28 February 2016

**RE: Arboricultural Assessment of Supporting Removal of Tree 130 Sydney Red Gum:  
MP10\_0016 - "The Terraces" 2 Cooper Street, Paddington**

**Ref: 246MonTree130[AR-RE-P-1008]**

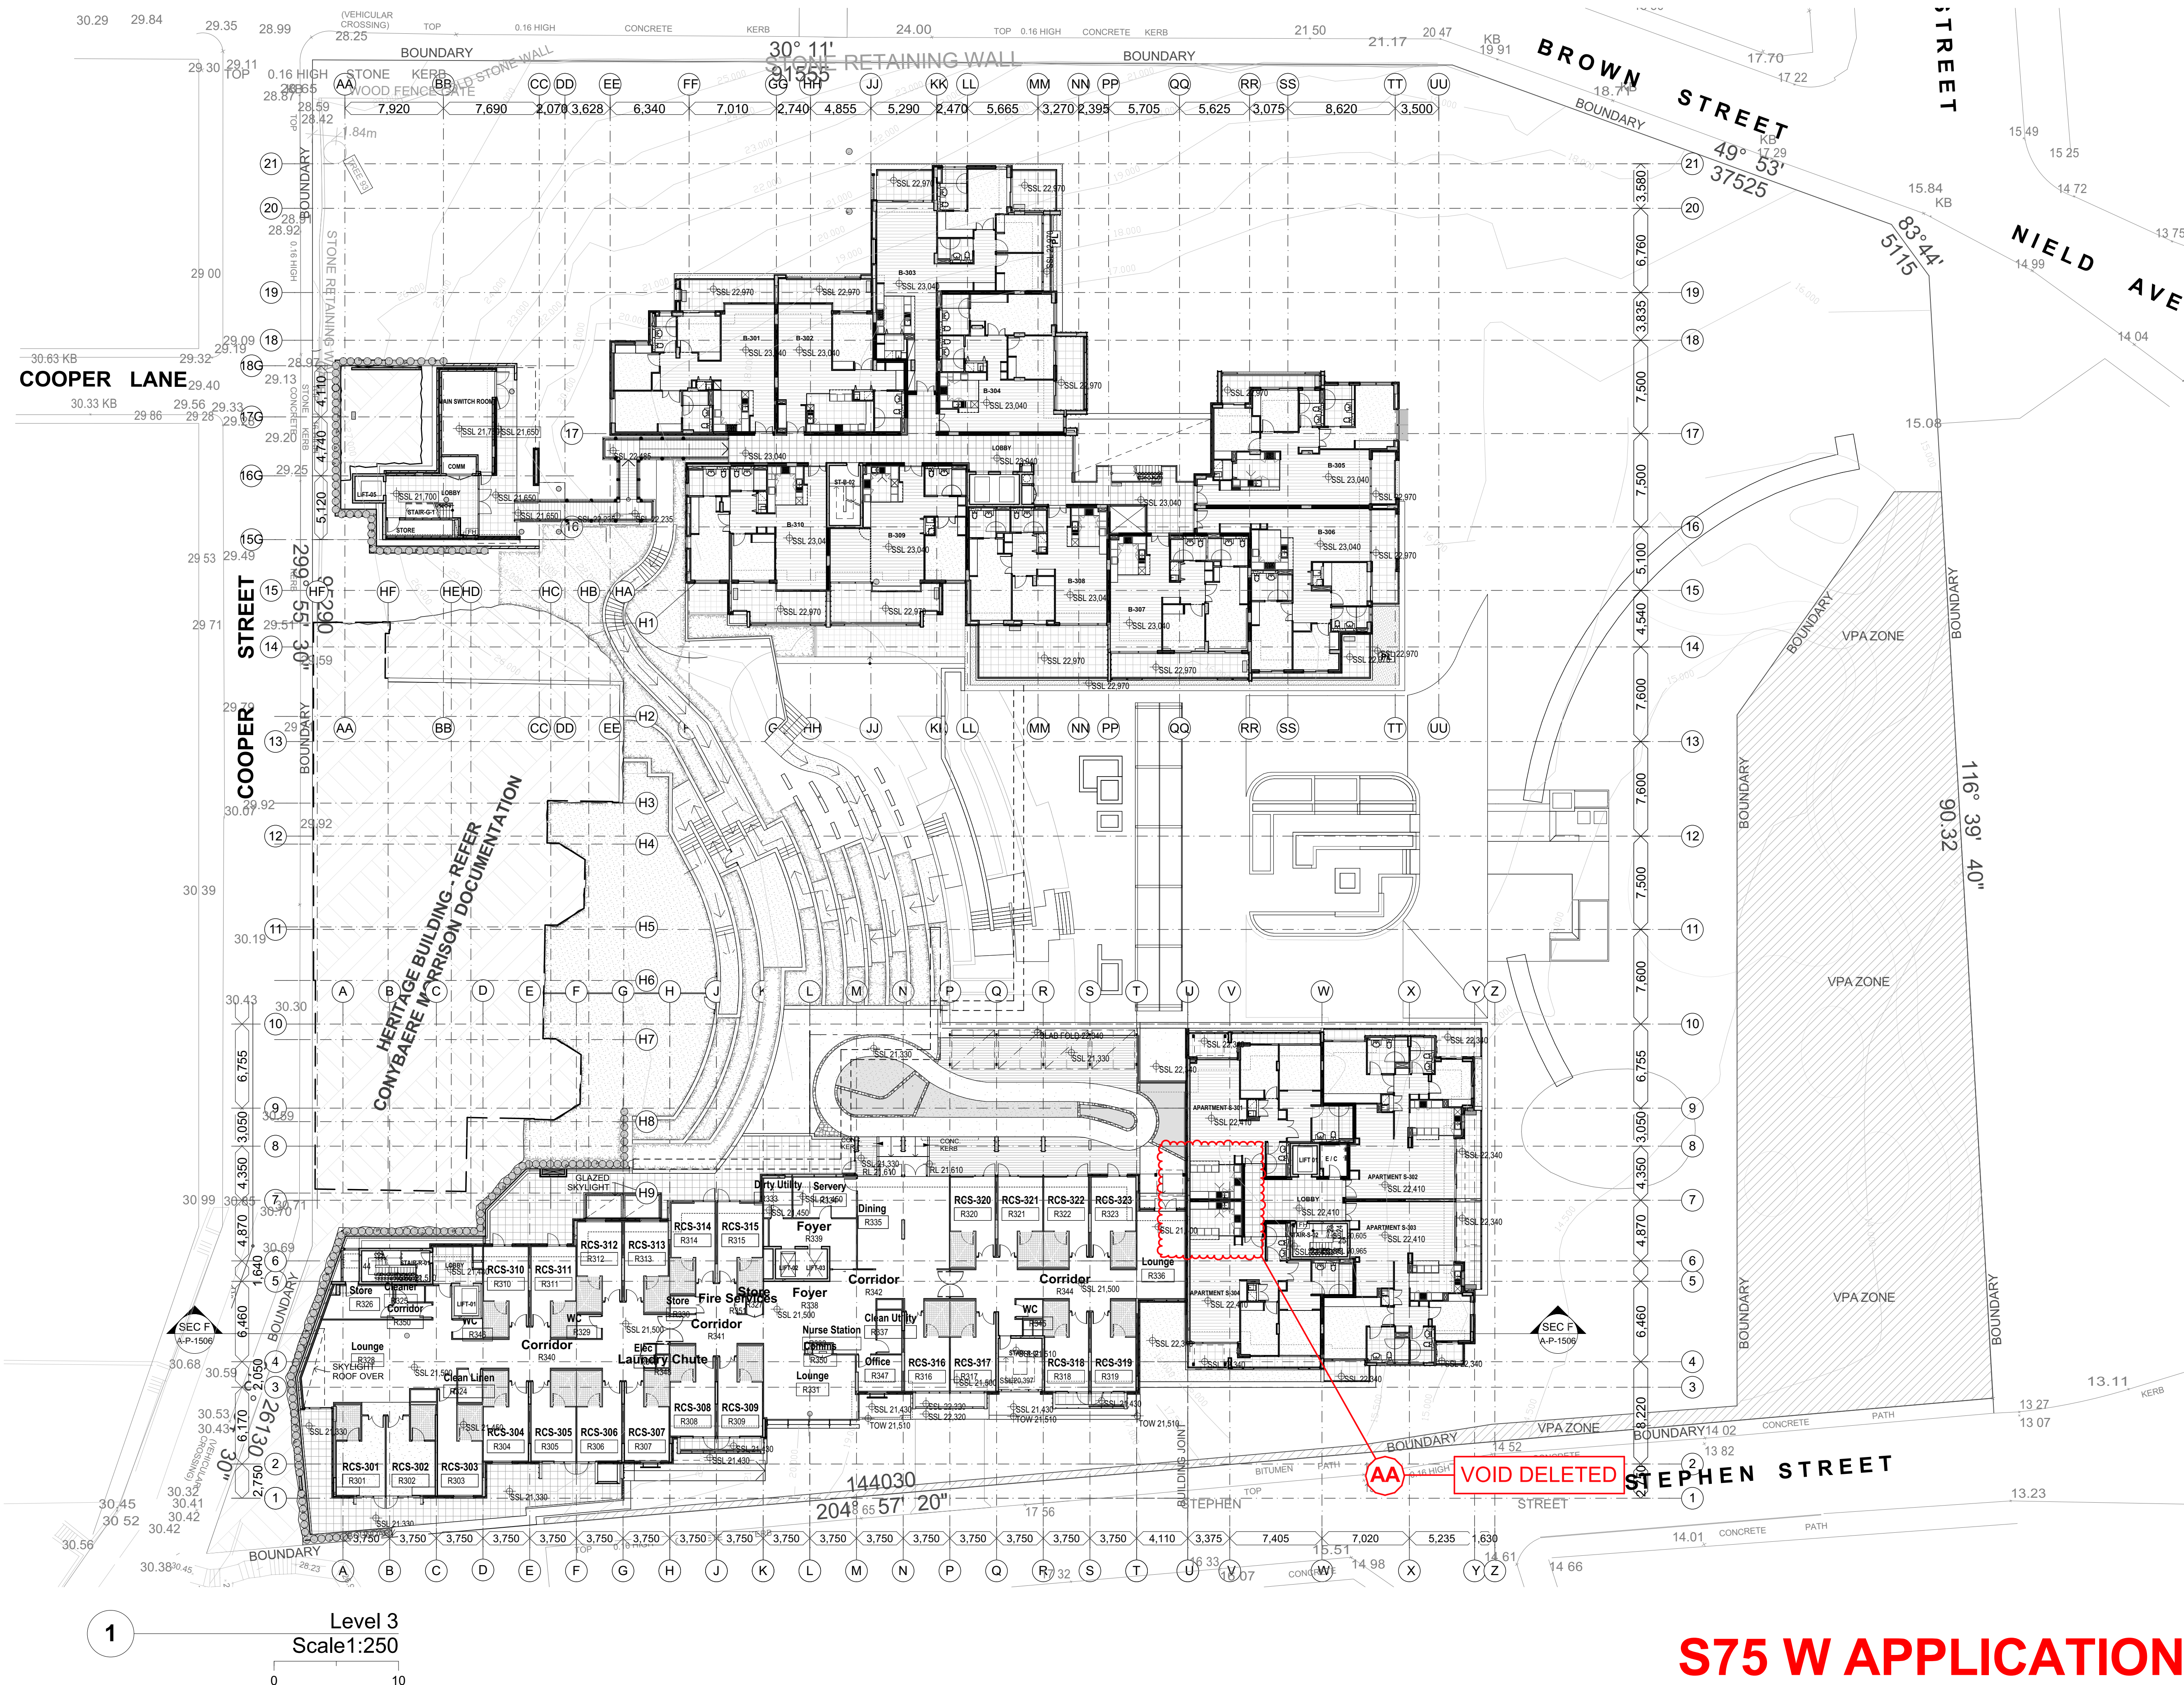
The current construction drawings show the actual trunk location well within the Structural Root Zone (SRZ) (2.8m) of the tree. In fact the excavation needed for the Driveway ramp down to the Basement is within 1m of the base of the tree and will result in root cutting on the tension side of the tree.

The External Works Sections Drawing A-P-1116, Rev 2 by JPRA has been marked up by Brookfield Multiplex Site Manager 3.12.06 (Attachment C) to accurately show the proposed excavation and the actual lean of the tree.

Section 1 shows the existing ground lines and proposed cut required for the Driveway ramp. Substantial cut for the proposed Driveway ramp is required at the base of the trunk to the west well inside the SRZ. Section 2 shows the cut required for the Basement (Grid line 15) within the Tree Protection Zone (TPZ) (7.2m) and excavation for the Basement (Grid line TT) within the SRZ. The tree will be destabilised by these combined excavation works within the SRZ, particularly given the lean of the tree away from Driveway ramp line of cut.

The crown of the tree is skewed to the south as indicated in Photo C, in the Survey excerpt above and as indicated in the External Works Sections markup (Attachment C). Substantial crown pruning would be required to allow for the proposed building facade and the scaffold required for the construction. As indicated in Section 2 (looking west) scaffolding is required in line with the base of the trunk. Even if the building were to be constructed without external scaffolding, the southern-most leader would need to be pruned to the main junction at approximately 3m above ground level and all the southern branches would need to be pruned to provide reasonable building clearance. This extent of crown pruning would render the tree significantly disfigured such that its ULE would be reduced and the landscape amenity provided by the tree would be lost.
